DRB	Application No.: 08DRB-70134 Project # 1006819
Proje	ect Name: SOUTH BROADWAY ACRES UNIT 1
Age	nt: THOMPSON ENGINEERING CONSULT\ Phone No.:271-2199
follo	request was approved on <u>3/19/08</u> by the DRB with delegation of signature(s) to the wing departments.  STANDING SIGNATURES COMMENTS TO BE ADDRESSED
30/00	TRANSPORTATION: Conneds
	WHW - 6
	UTILITIES:
<b>#</b>	CITY ENGINEER / AMAFCA: 57/1
	PARKS / CIP:
	PLANNING (Last to sign):
	Planning must record this plat. Please submit the following items:  -The original plat and a mylar copy for the County Clerk.  -Tax certificate from the County Treasurer.  -Recording fee (checks payable to the County Clerk). RECORDED DATE:  -Tax printout from the County Assessor.  3 copies of the approved site plan. Include all pages.  County Treasurer's signature must be obtained prior to the recording of the plat with the County Clerk.  Property Management's signature must be obtained prior to Planning Department's signature.  AGIS DXF File approval required.  Copy of recorded plat for Planning.

On December 20, 2007, the Environmental Planning Commission approved Project # 1006819, 07EPC-40047/40076, a sector development plan map amendment and a

SITE PLAN
1" = 30'

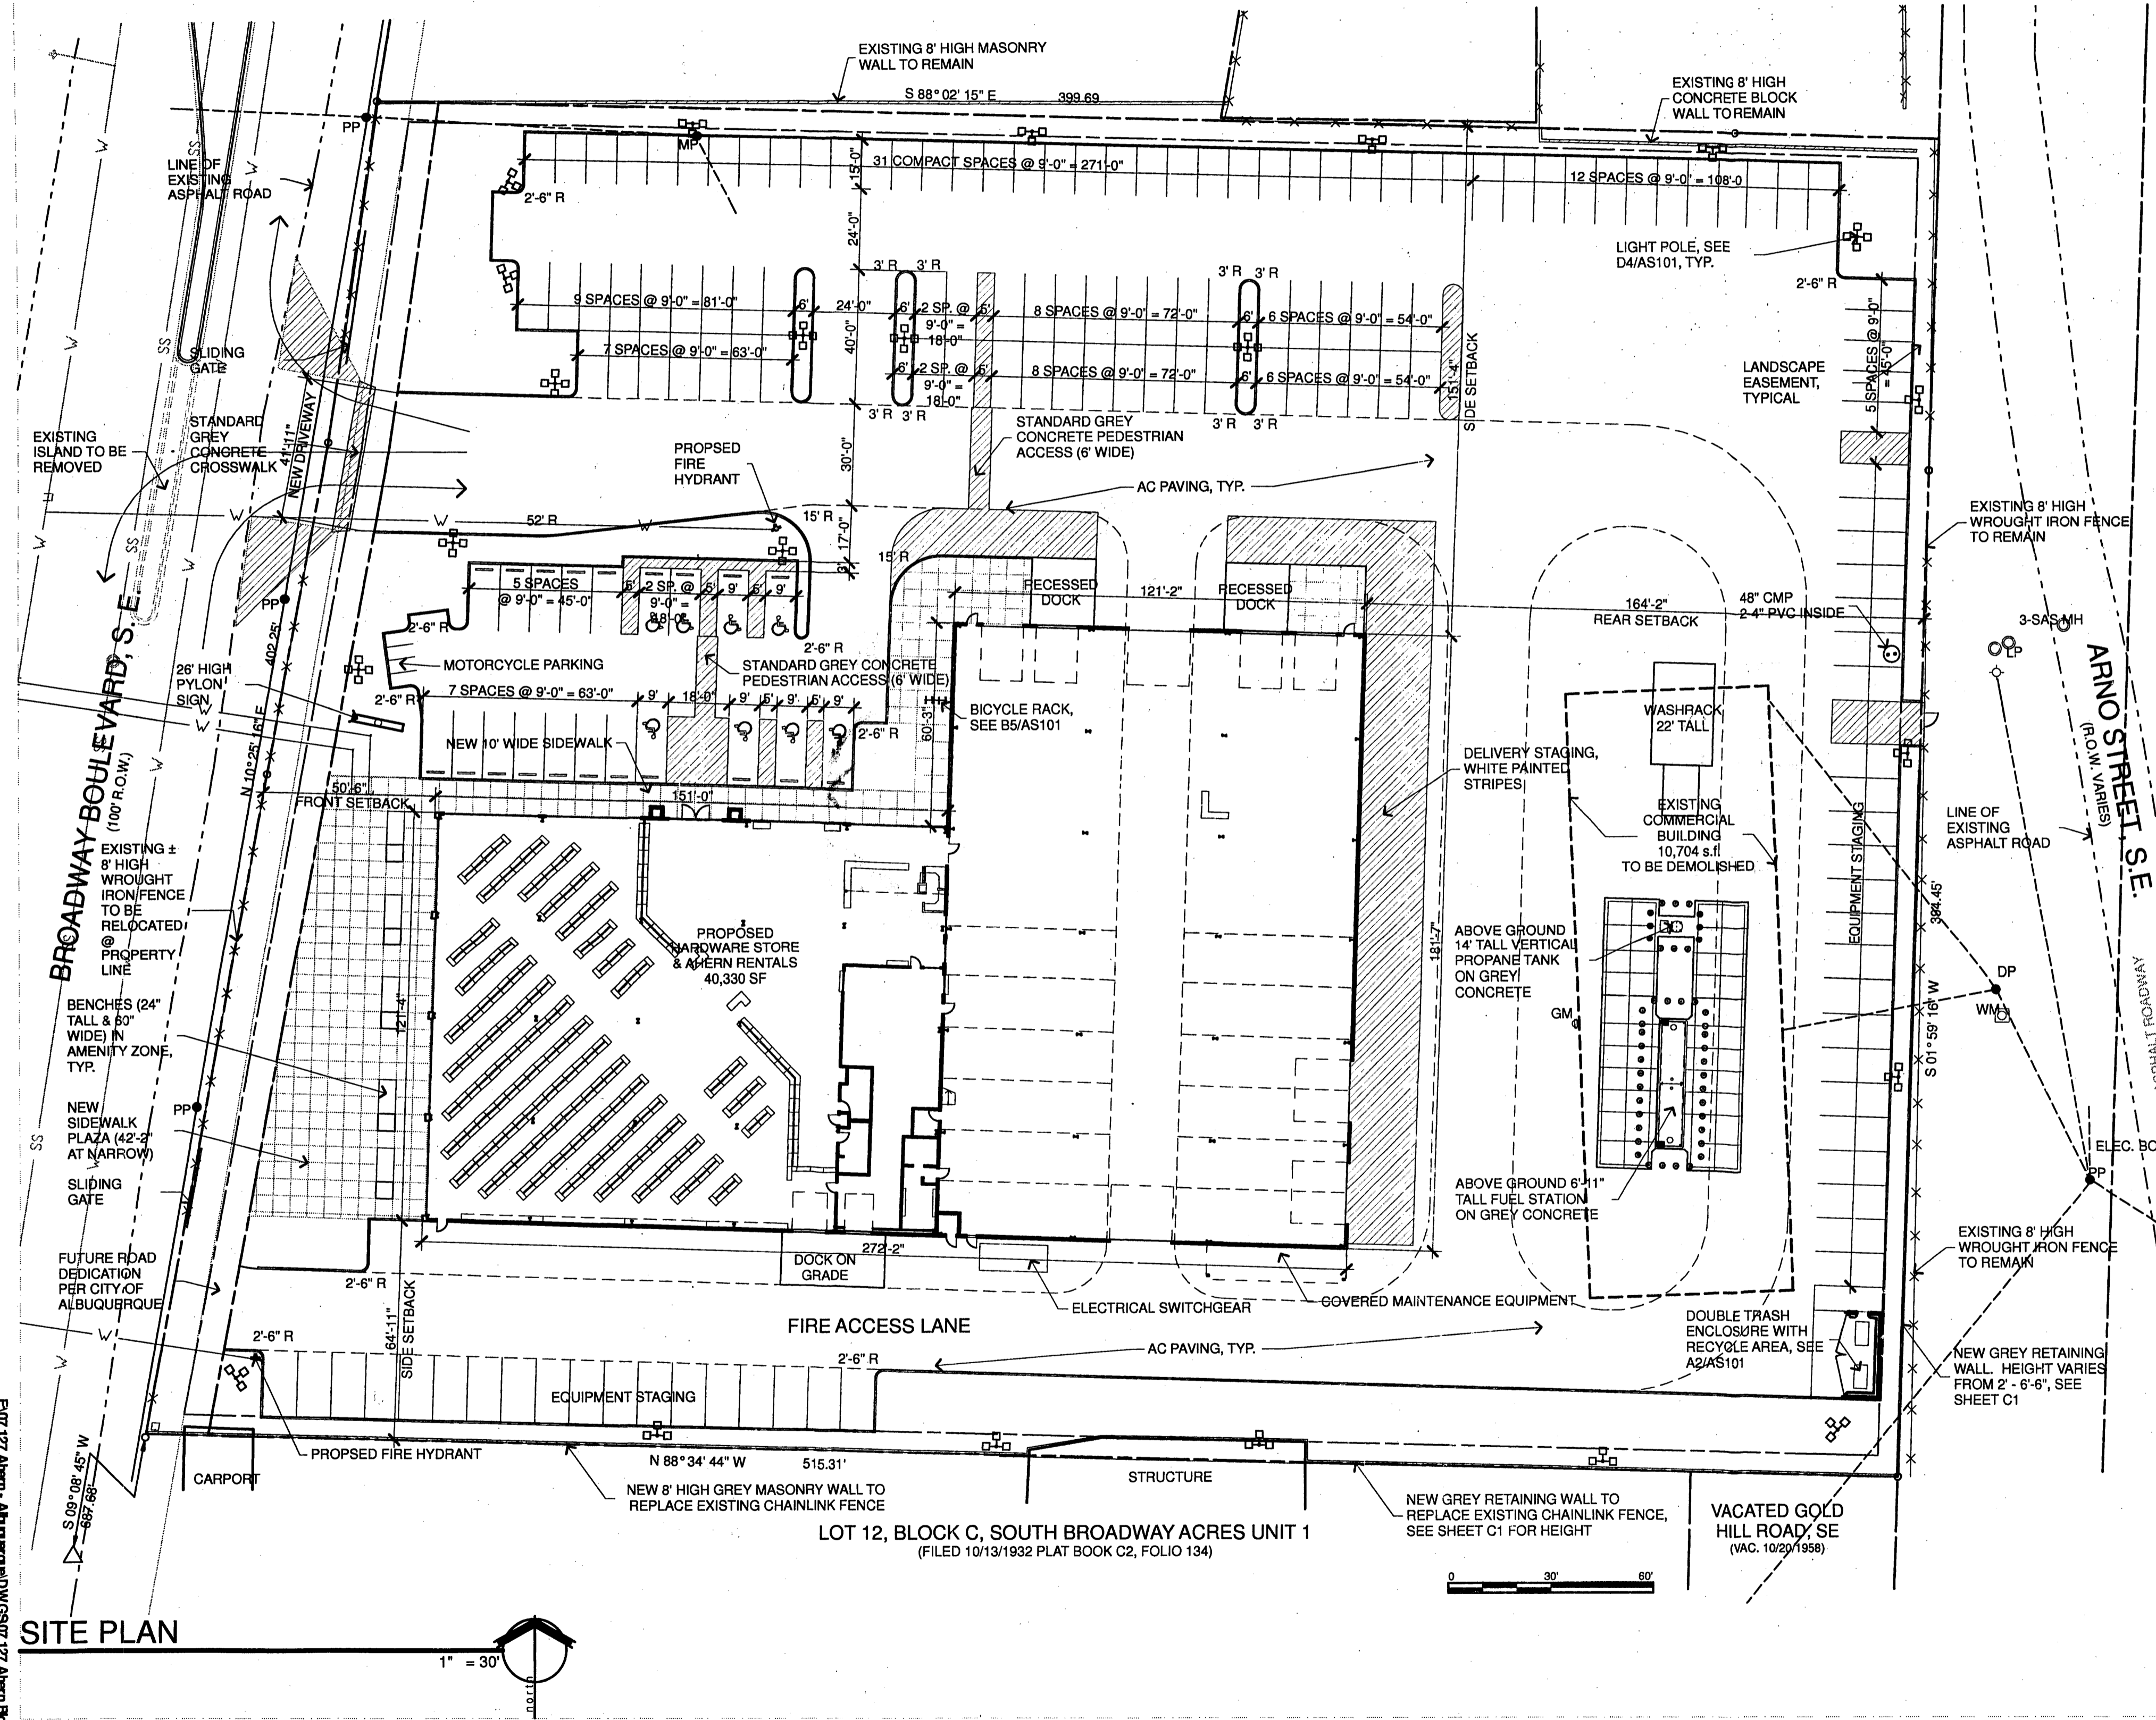
- Item 1. The site plan has undergone minor changes to the parking layout in the northwest corner of the site. The loading dock on the south side has been deleted.

- Item 2. We met with Randall Faulkner and all drawings and revisions have been approved.
- Item 3. The site plan and planting plan have been revised to show the correct alignment of Arno Street.

**BUILDING
 ELEVATIONS**

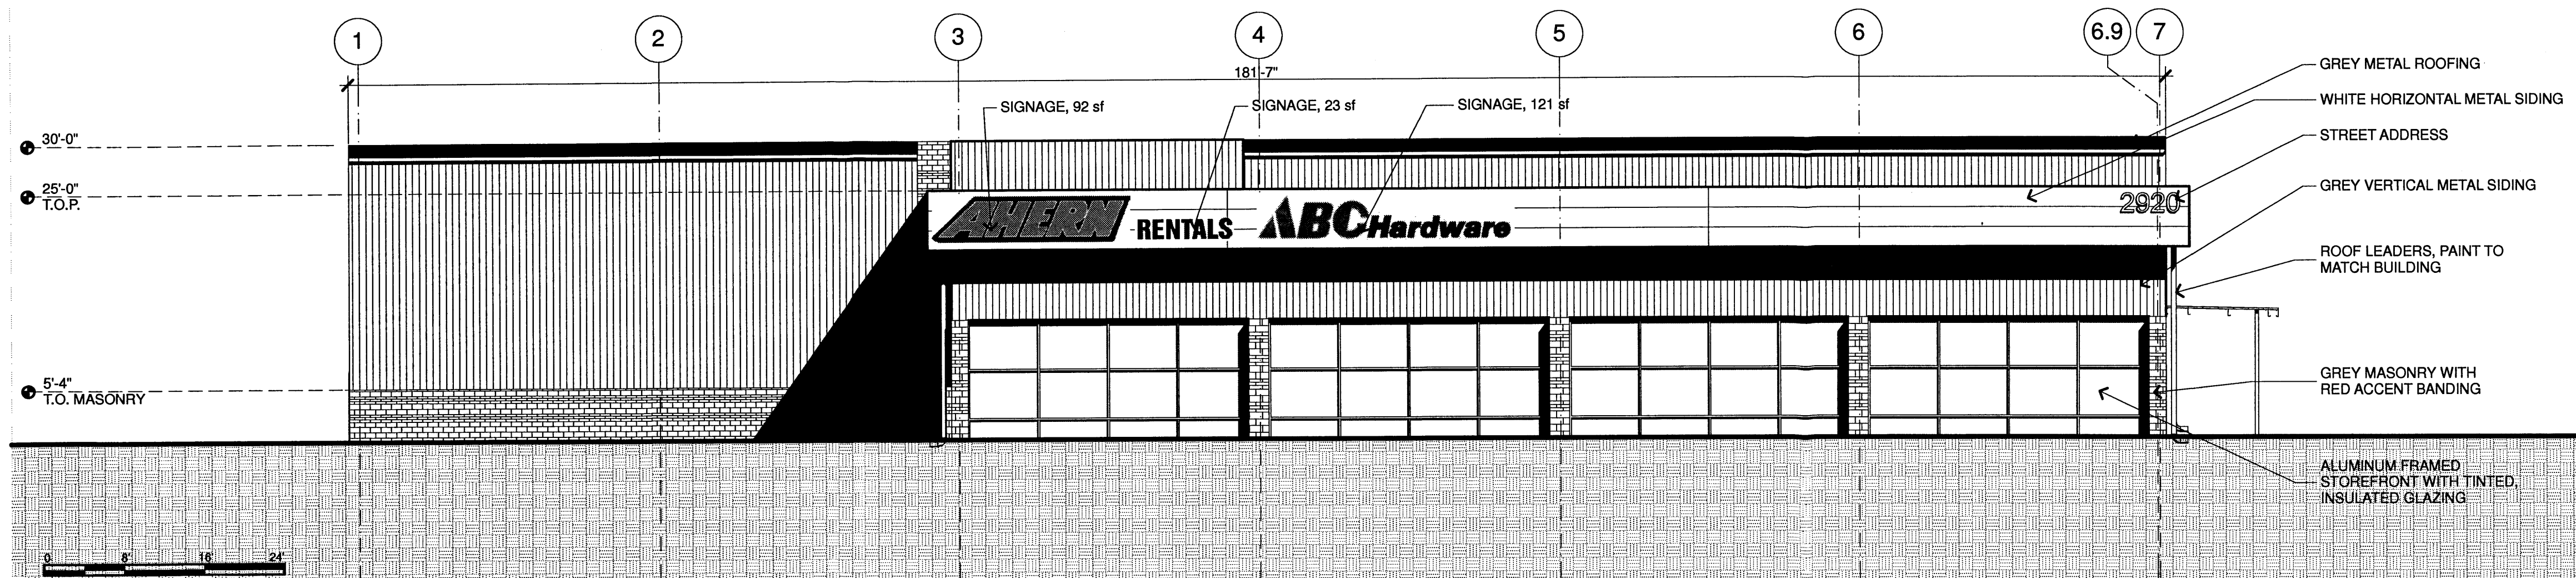
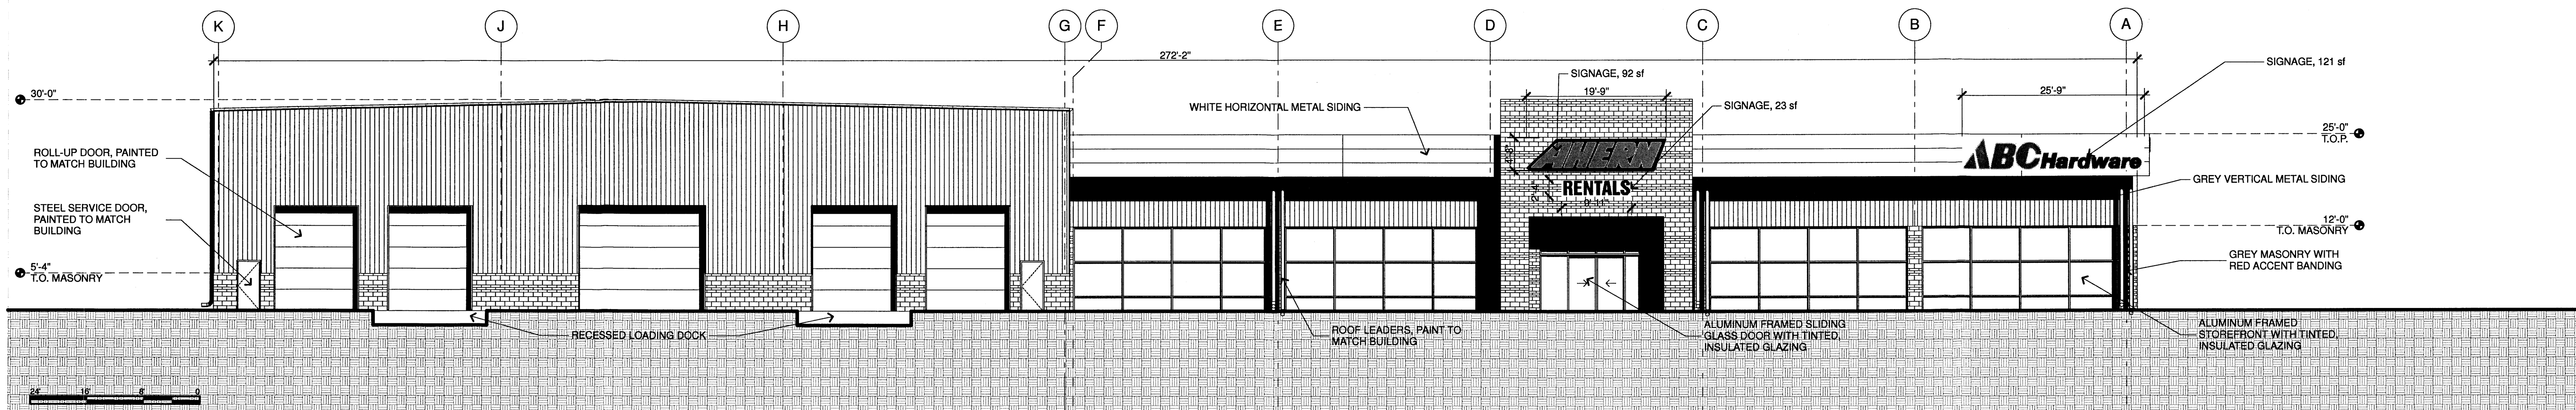
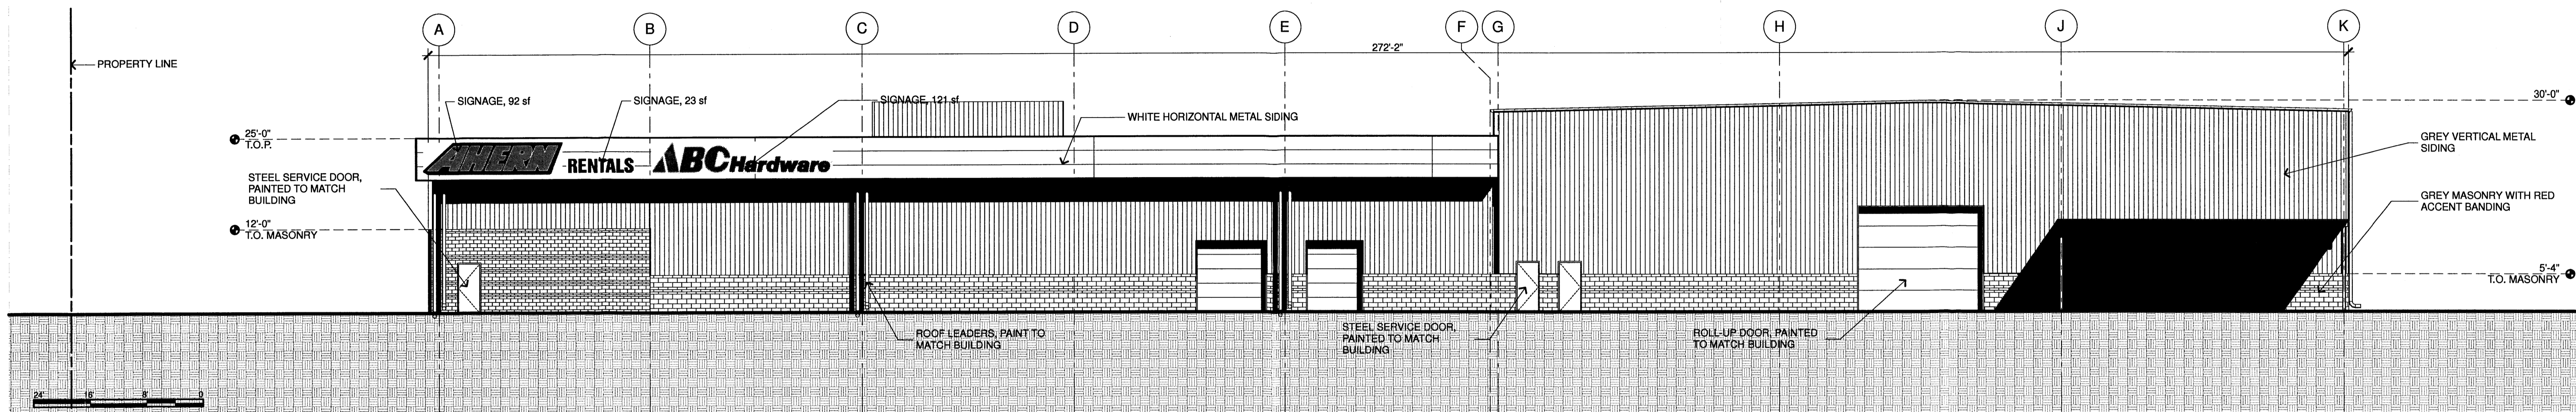
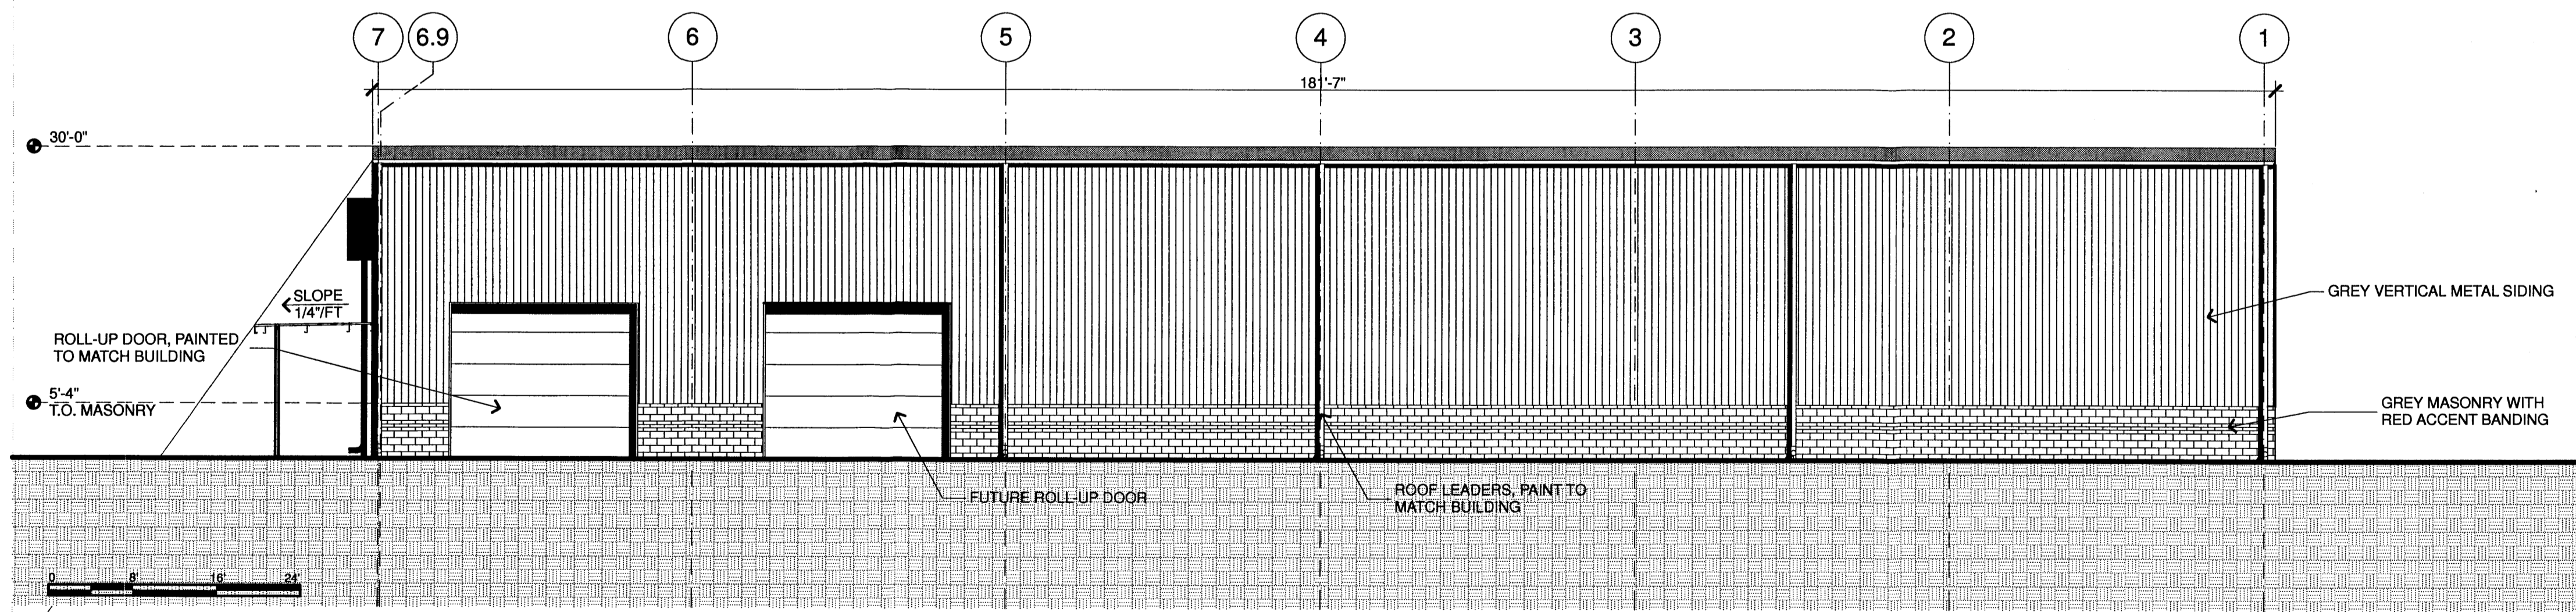
- Item 10. The grading and drainage plan and the conceptual utility plan have been drawn to scale.
- Item 11. The building elevations have been revised to show the length of the buildings.
